H05/0944/00

Amendment: Resiting of dwelling, turning facility deleted, design
alterations, plus drainage/landscaping details

AMENDED PLAN

RE: PROPOSED BUNGALOW AT HALLGATE FLEET FOR JMG HOMES

SITE/LAYOUT
 PLAN
 SCALE: 1:100
 DRWG NO: SC244/05
 OCTOBER 2000

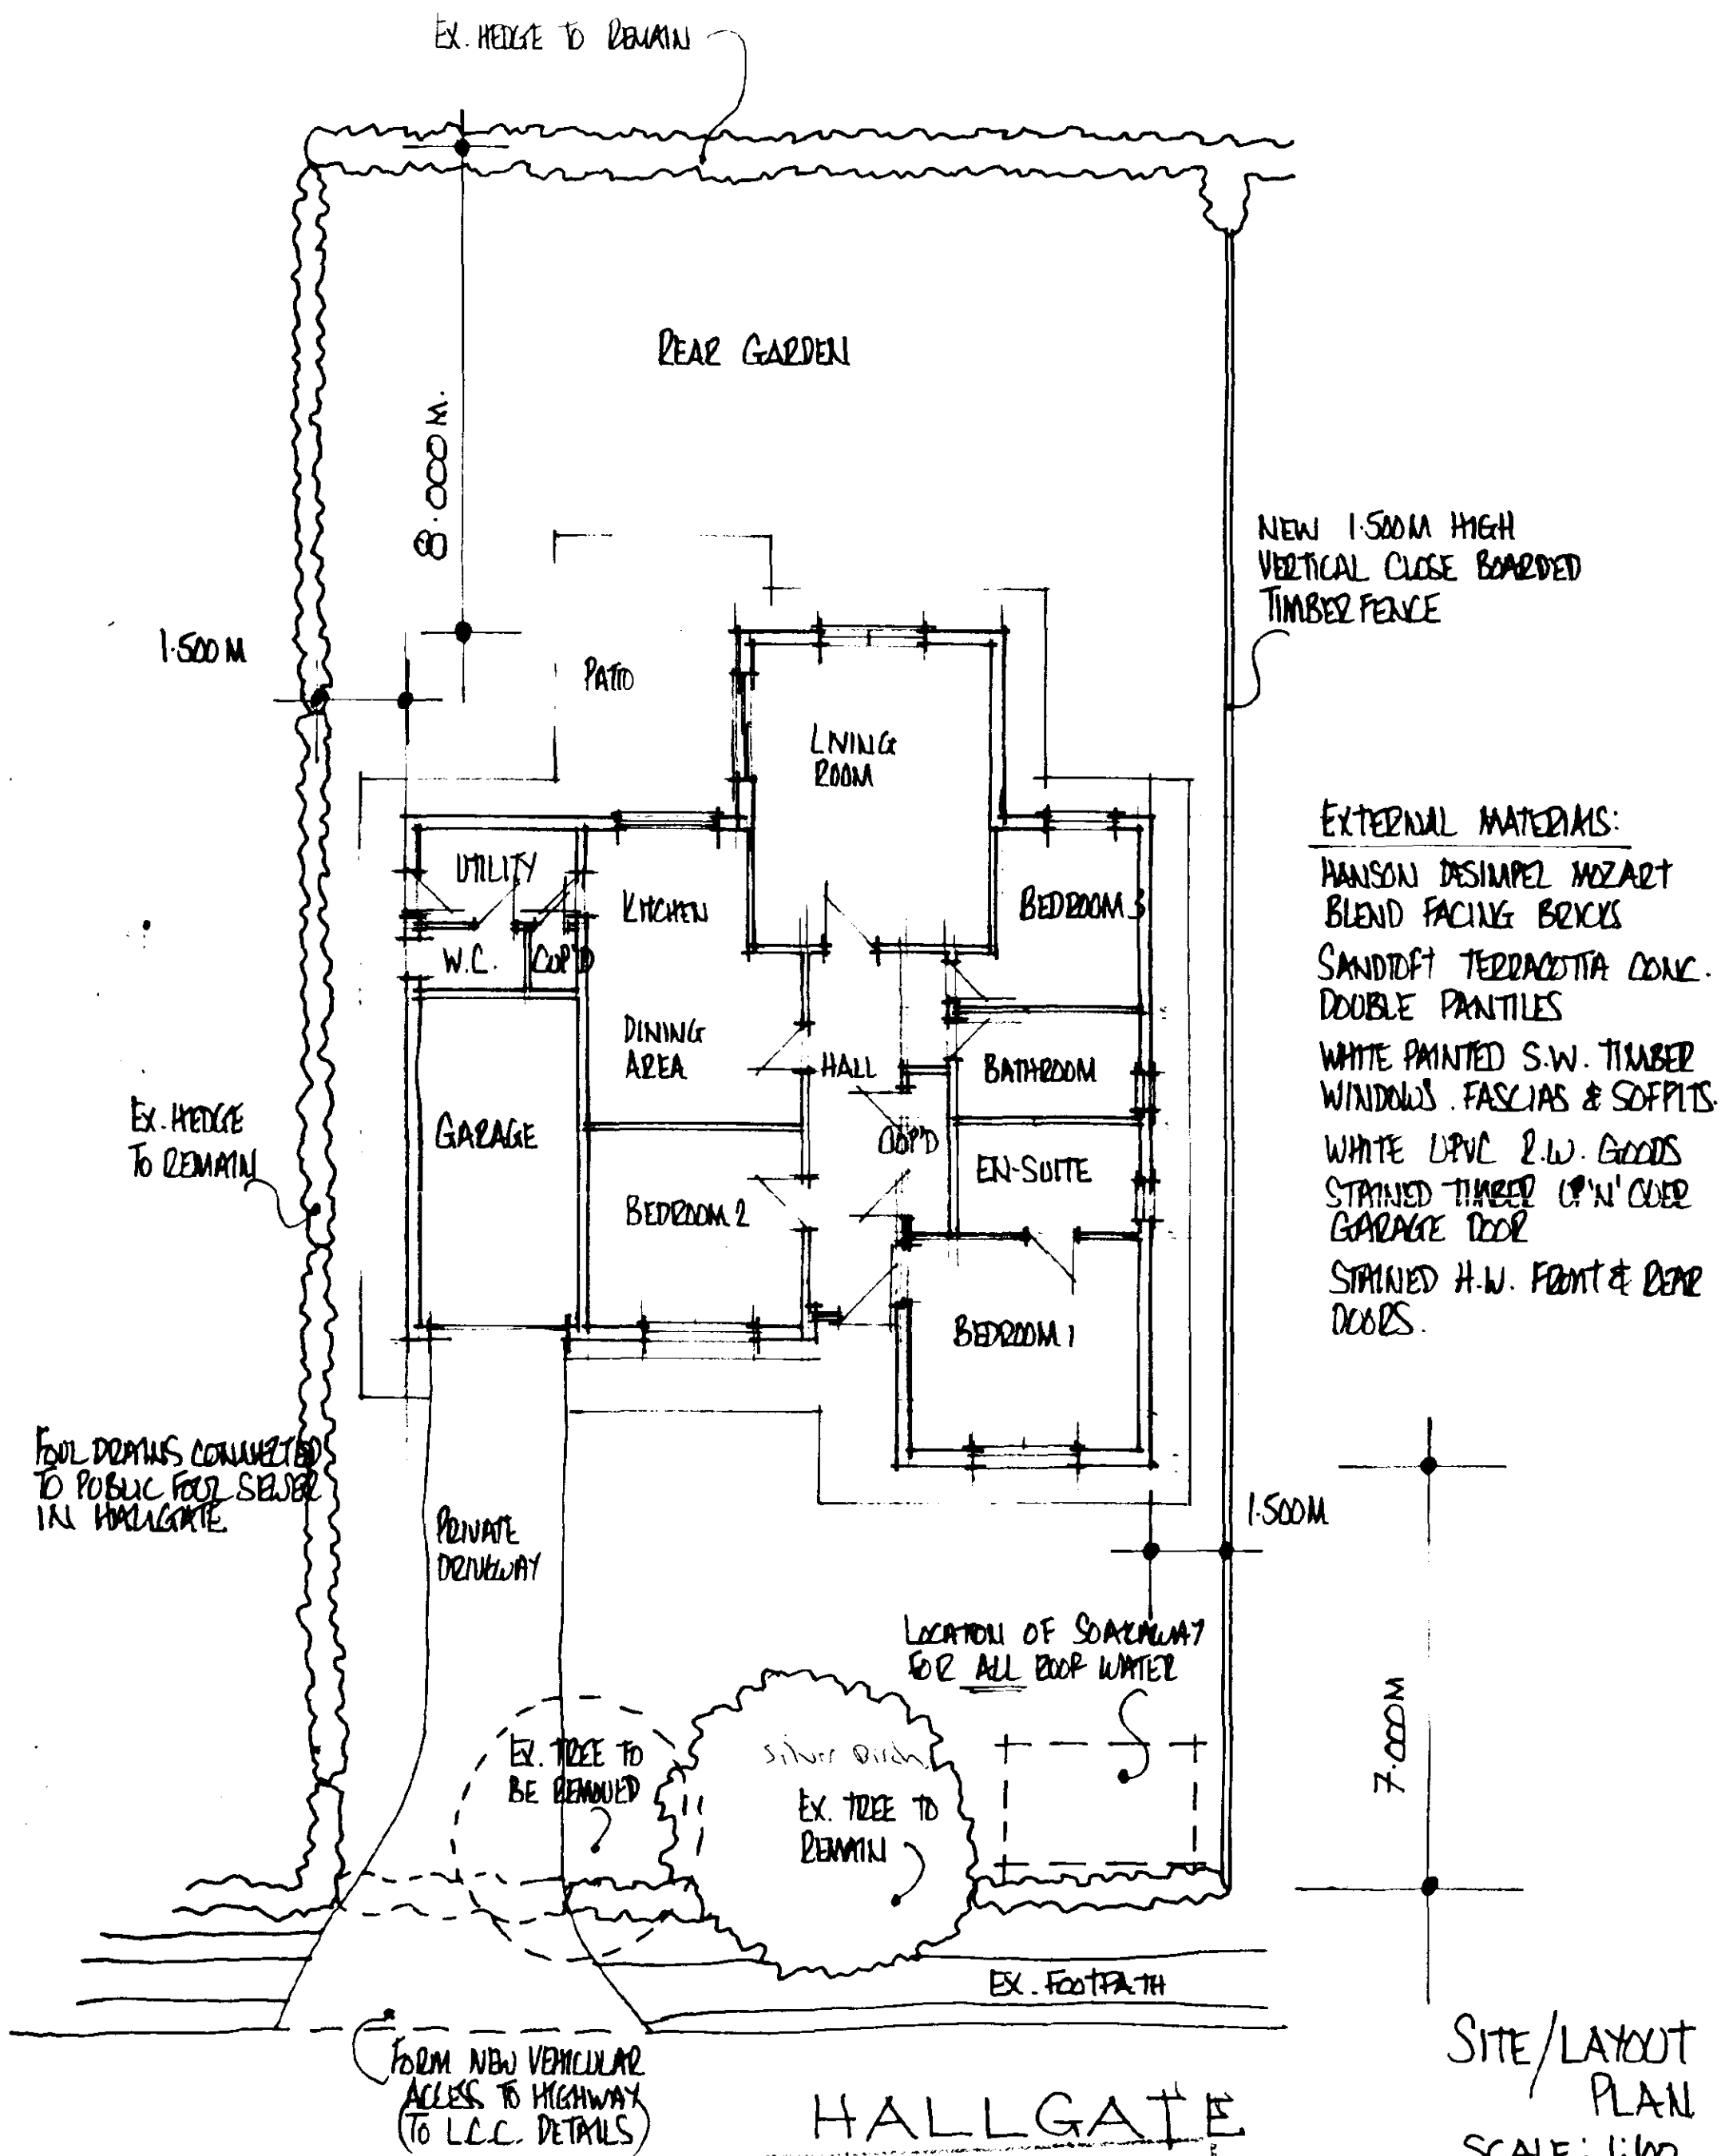
- a) Bungalow brought forwards by 4.0m
- b) Turning facility deleted
- c) Gable end timber detail deleted
- d) Oversailing detail brickwork to all gables instead of barge boards
- e) Chimney added to one gable end
- f) Windows, fascias and soffits to be white painted softwood
- g) Soakaway for all roof water situated at front of site
- h) Confirmation that the site contours will not be altered from that as existing
- i) Confirmation that from 2 no test bores dug on site the sub-soil is sandy silt down to a depth of at least 2.4m
- j) Confirmation that all perimeter hedges shall be retained and 2 no. tree retained along the plot's frontage. 1 no. small tree is proposed to be removed to allow for the new vehicular access.
